Date: 11/13/2025

Re: **Notched I-Joist**
Location: Lot 46 Birchwood Trails (98 Spy Glass Dr. Fuquay-Varina, NC)
JDS Project No.: RDU2511636
Date of Inspection: 11/13/2025

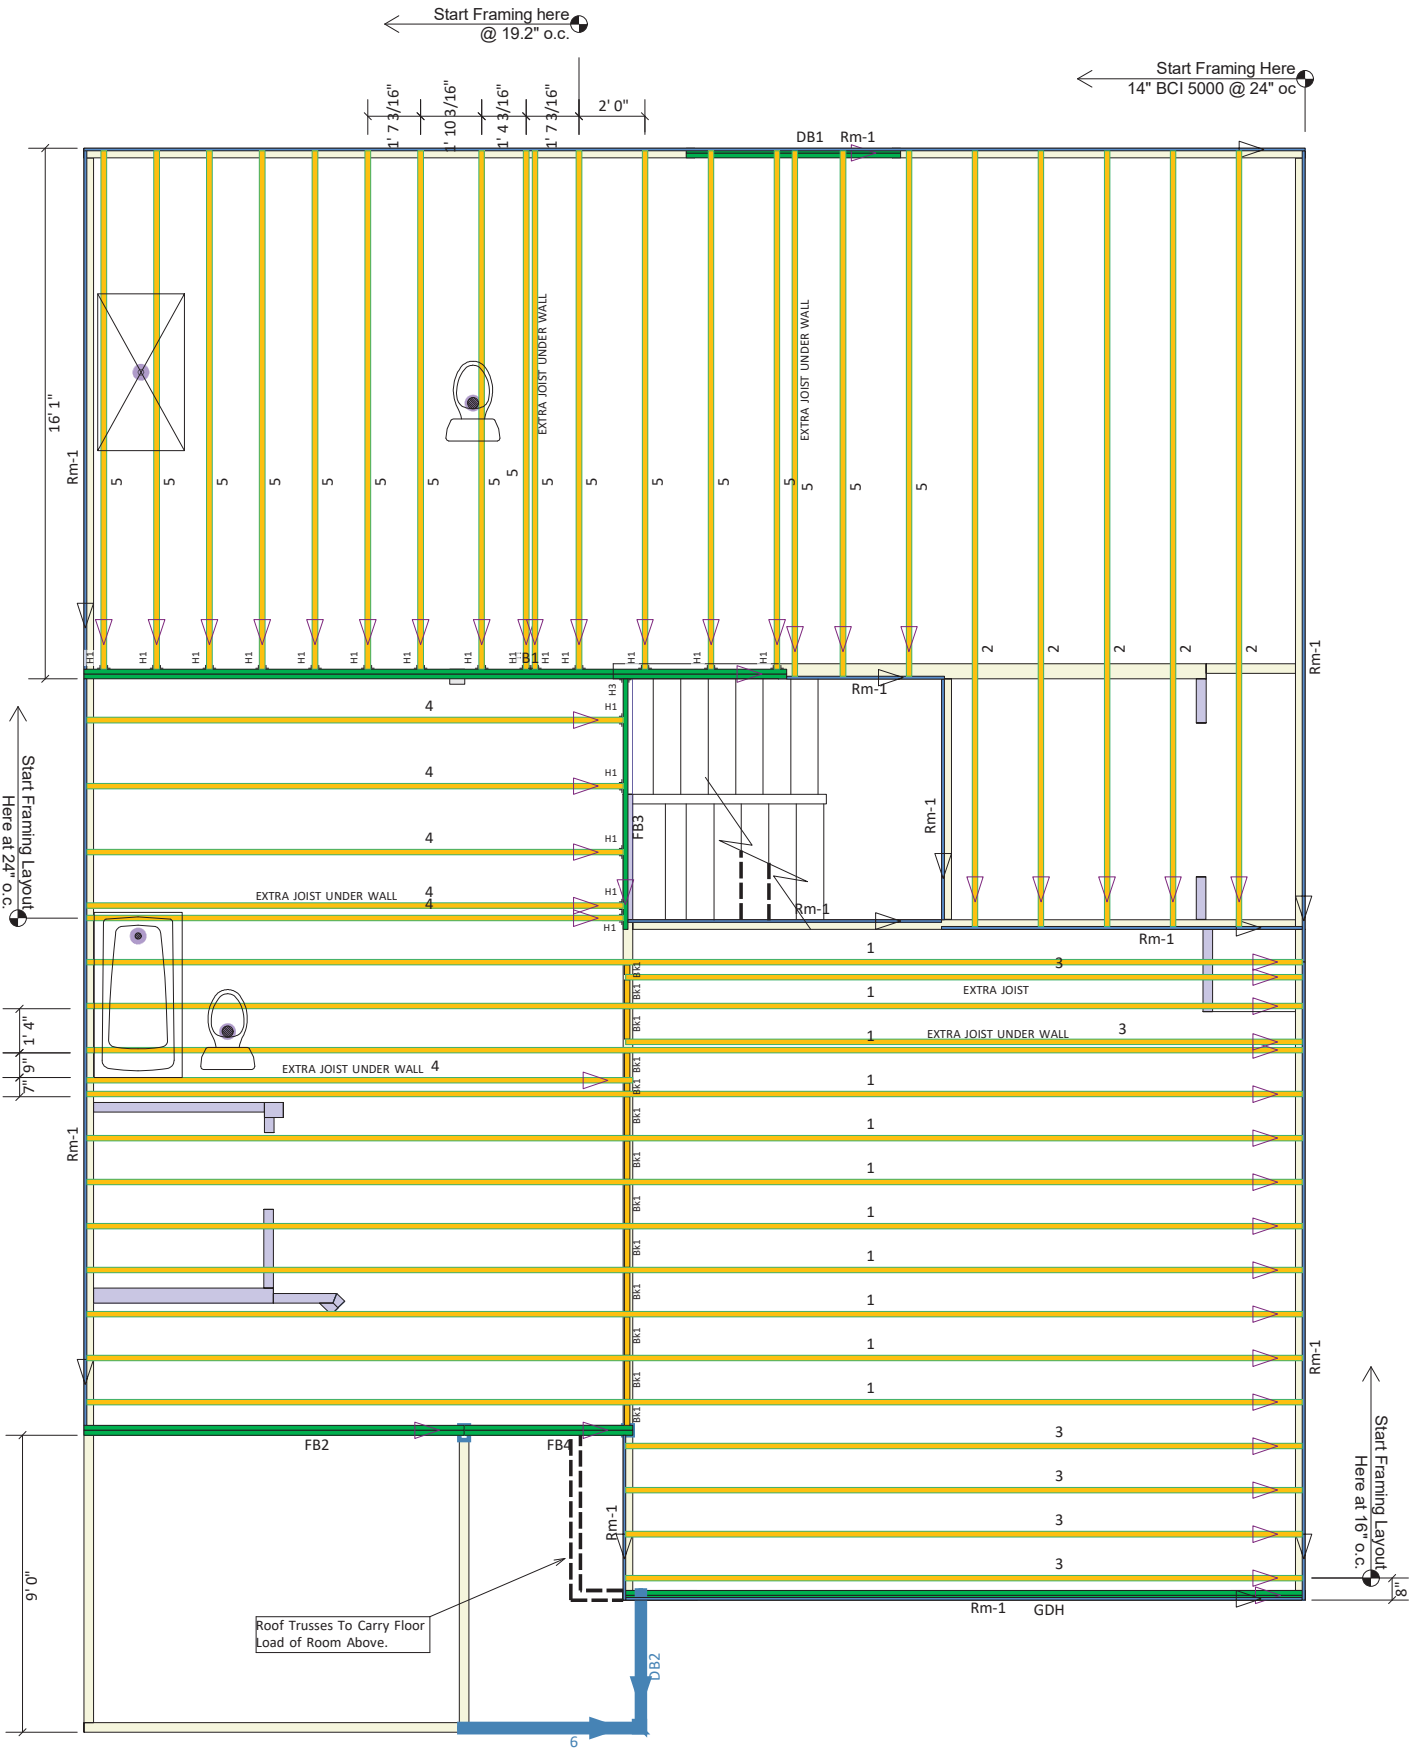
Above the dining room the 3rd I-joist from the front dining room wall has had the top flange nicked by drilling for the installation of a plumbing drain on the rear face 4' from the left wall.

Based on our onsite observations and review, pack out one face of the web with a 4' strip of 3/4" OSB cut to fit tight between the top and bottom flanges, centered on the damage and attached with construction adhesive and (3) 6D nails at 3" o.c. Then, install a 4' 2x4 scab flush to the bottom of the bottom flange, on top of the pack out, centered on the damage and attached with (2) 10D nails at 4" o.c. with (1) nail in the flange and (1) nail into the web.
